## Cockle Bay Wharf – Response to Public Submissions

Table 1 below provides a summary of the matters raised within each public submission received. Table 2 provides a summary of each matter raised within the submissions and provides a response.

ASTORIA WESTERN  
FACADE ANALYSED

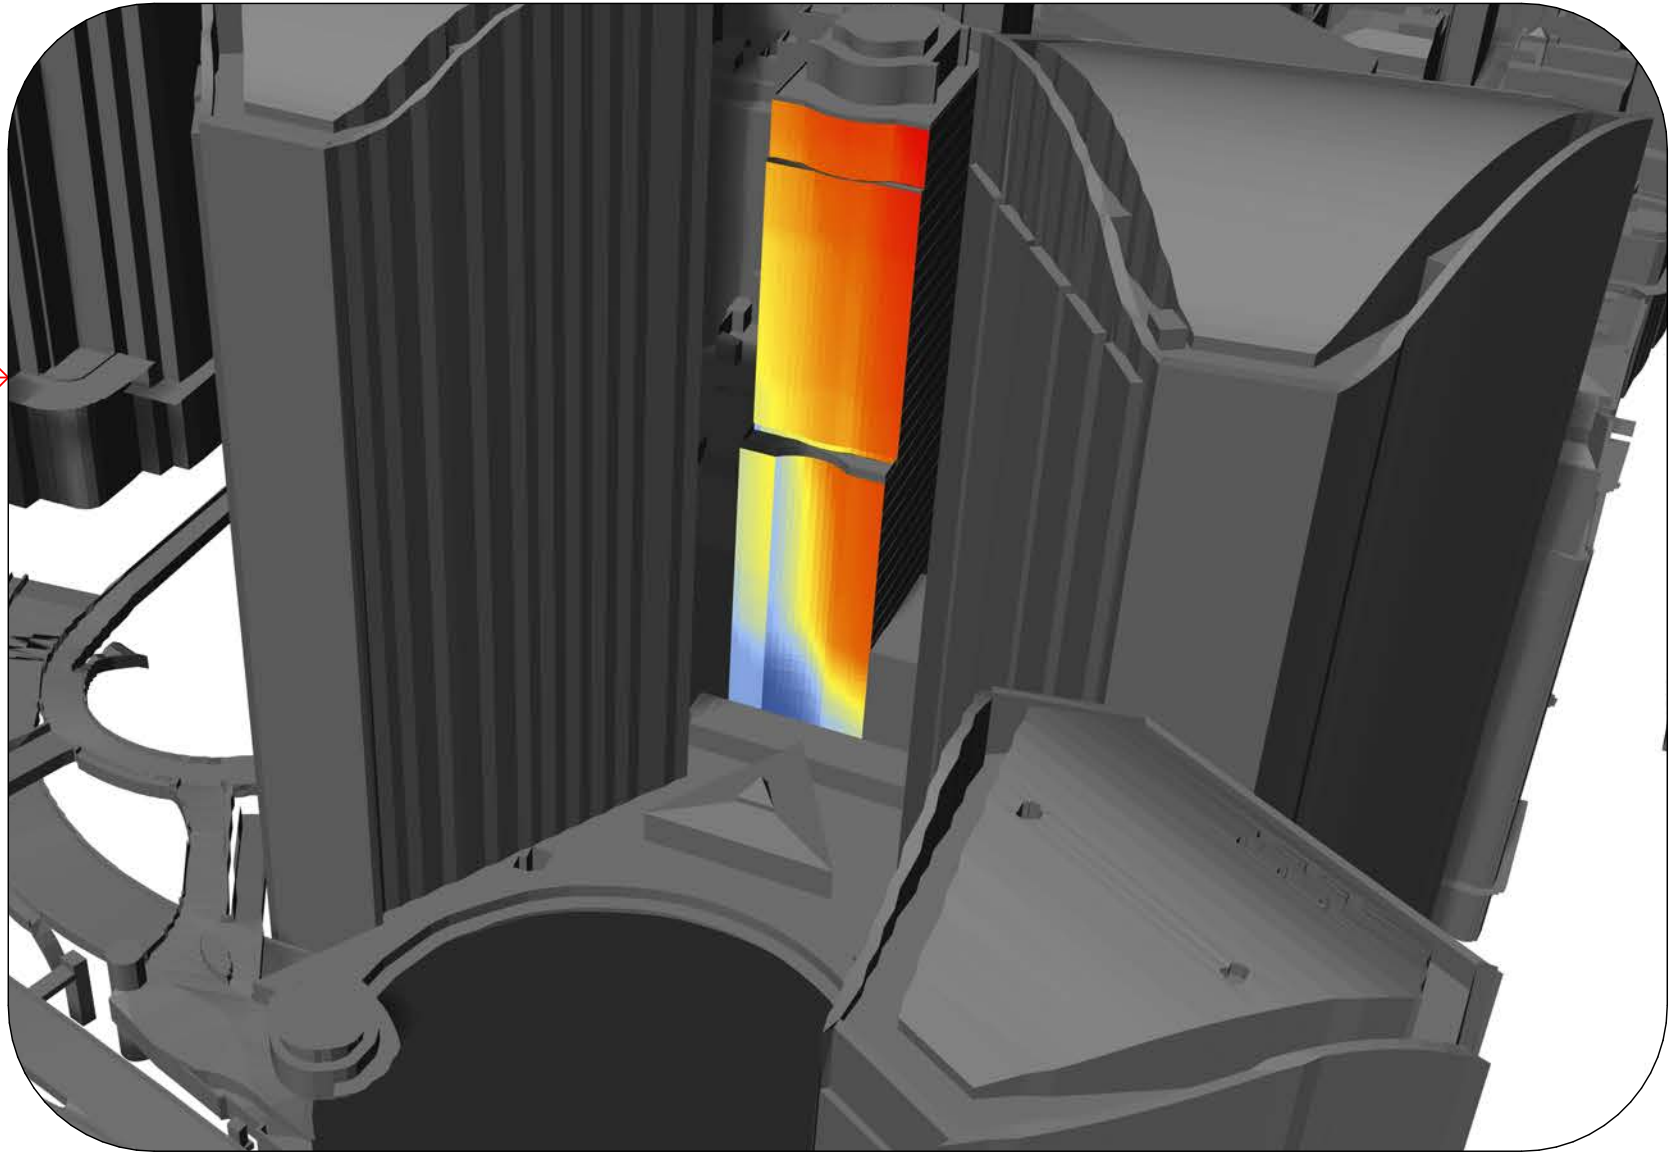
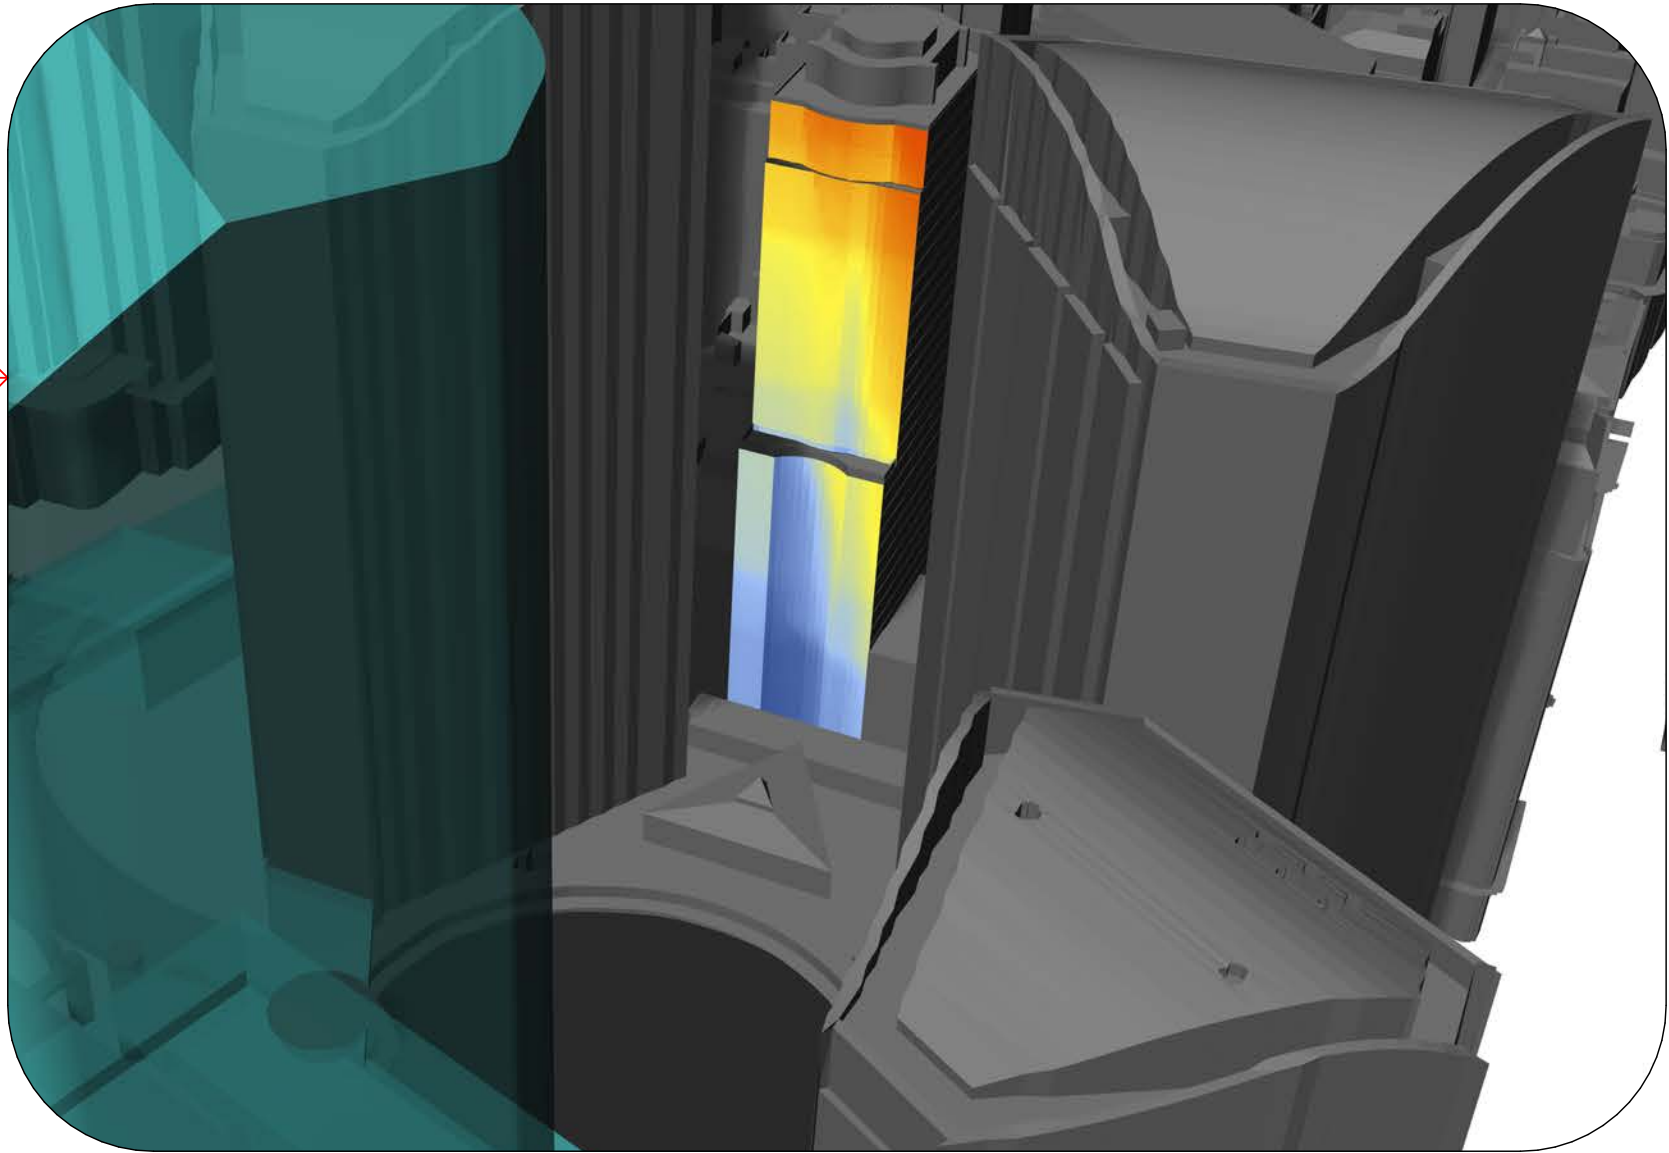
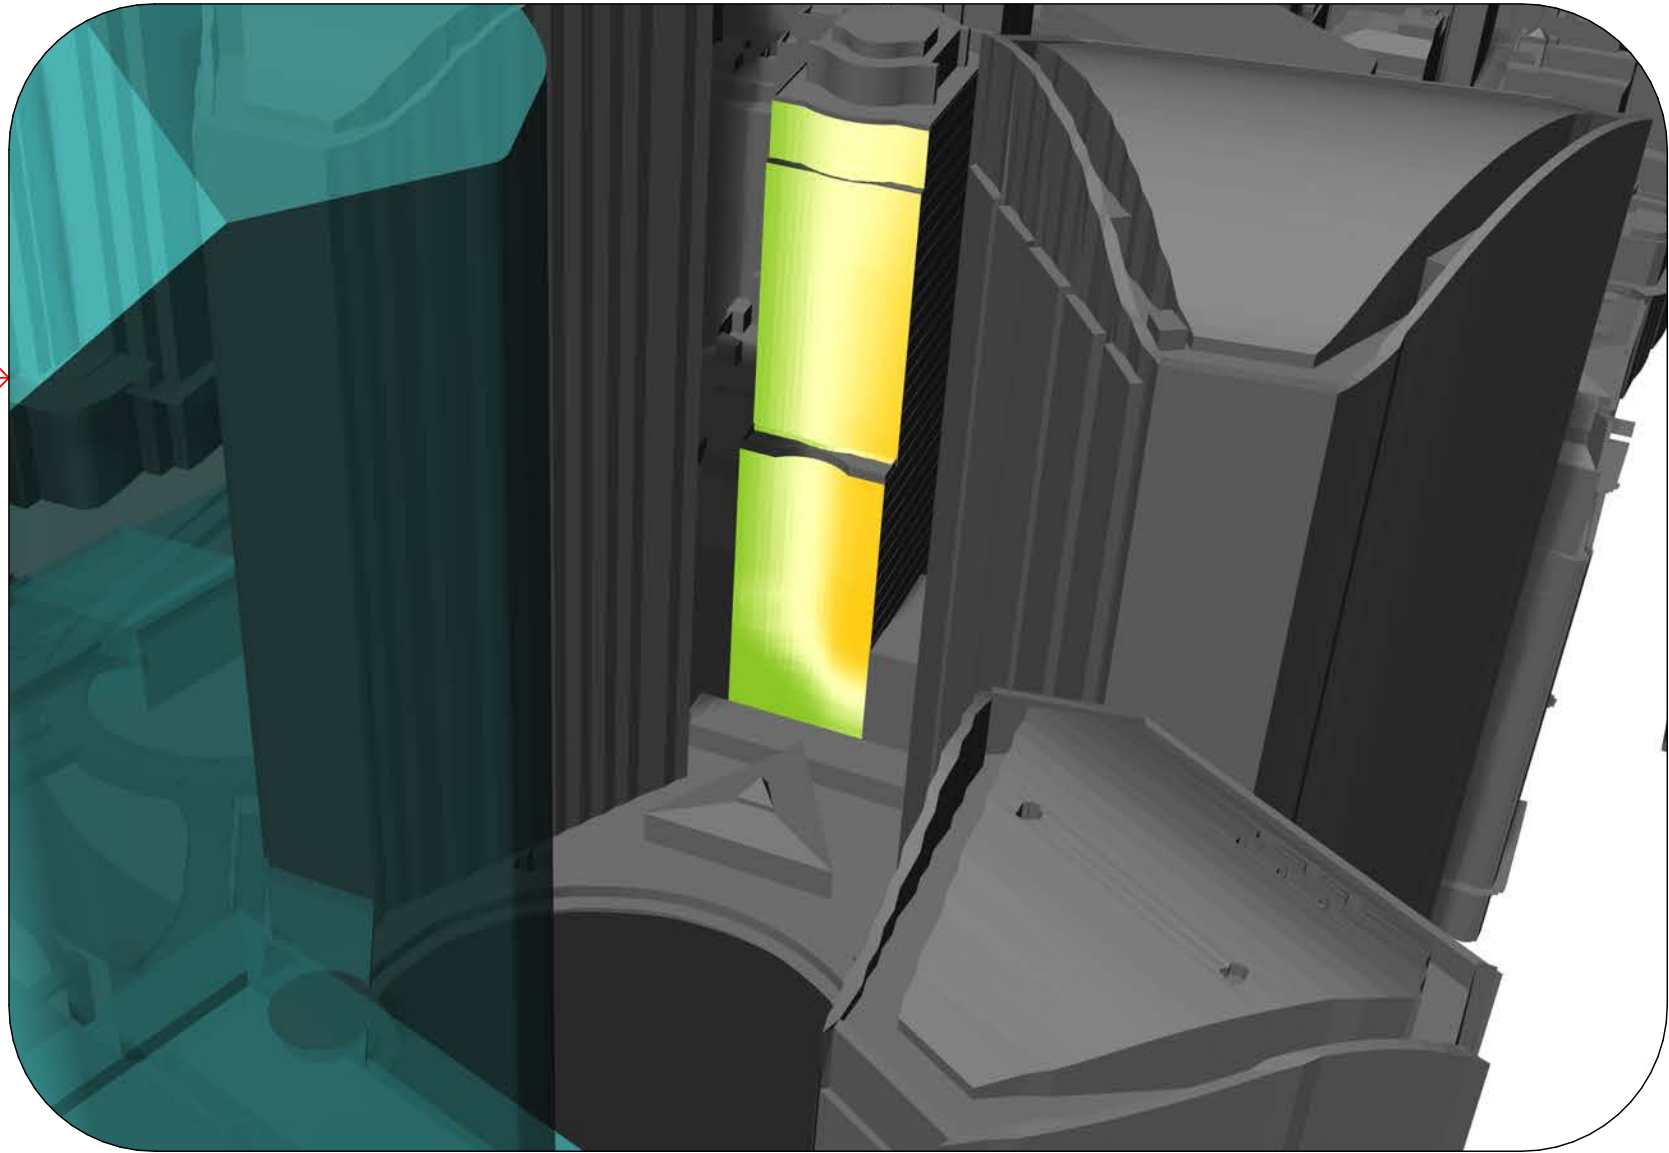
<h3>Overshadowing</h3>	
<p>The proposed tower will heavily overshadow a number of buildings in the areas bounded by Sussex Street, Druitt Street, and Kent Street</p>	<p>The proposed development is for a Concept Envelope, within which a tower can be proposed in the future. A future tower on the site would overshadow a number of buildings within the Sydney CBD. In designing the Concept Envelope priority has been given to avoiding overshadowing impacts to publicly accessible open spaces. Publicly accessible open spaces which have been prioritised include Tumblong Park, Town Hall Steps, Sydney Square, The Cockle Bay Foreshore Promenade, and the Future Town Hall Square.</p>
<p>The proposal will prevent the continuation of installing solar panels on the rooftop as an energy-saving initiative (447 Kent Street)</p>	<p>The proposed development is for a Concept Envelope, within which a tower can be proposed in the future. The overshadowing of the Concept DA has been determined as acceptable at the Concept level as described at Section 5.3 of the RTS. A further overshadowing study will be</p>

Item Raised	Proponent's Response
	<p>prepared once a building is proposed on the site in Stage 2 of the DA process which may minimise and refine the impact of the Concept Envelope.</p>
<p>The structures will cause significant overshadowing and dominate the public domain</p>	<p>The exhibited proposal demonstrated limited overshadowing of the foreshore promenade and Cockle Bay water. A full assessment of that overshadowing was included within the 2017 EIS.</p> <p>Following refinements to the design of the Concept Proposal additional overshadowing studies have been undertaken and are provided in <b>Appendix C</b> and in Section 5.3 of the RTS.</p>
<p>The future Town Hall Square opposite Sydney Town Hall will have reduced sun access as a result of the proposed tower</p>	<p>It is acknowledged that the amended Concept Proposal results in the potential for minimal overshadowing of the future Town Hall Square for a short period of time during the year and after 4pm. Notwithstanding, the potential minimal overshadowing is considered reasonable in the circumstances for the following reasons:</p> <ul style="list-style-type: none"> <li>• The draft Central Sydney Planning Strategy proposes to introduce additional “no additional overshadowing” control to the future Town Hall Square between 12pm and sunset (year-round). The draft CSPS has not yet been publicly exhibited and is therefore not a formal matter for consideration under S79C of the EP&amp;A Act.</li> <li>• Notwithstanding, overshadowing is restricted to a 25 – 30 minute period near sunset between 4:00pm and 4:30pm (AEST) on the most affected day (9 September / 1 April if a tower is located in the north of the Concept Envelope and 14 September / 27 March if a building is located in the south of the Concept Envelope) Impacts are reduced to zero over a twelve day period on either side of that day.</li> <li>• The Concept Proposal provides a significant waterfront open space with ample solar access for the majority of the day located on the northern side of the proposed tower. The form of the proposed podium and tower frees up this space for public use. This major piece of new open space should be viewed against the minor (and reduced) impacts on Town Hall Square and which have been reduced since the initial exhibition.</li> <li>• Further information in relation to this can be located in in <b>Appendix C</b> and in Section 5.3 of the RTS.</li> </ul>
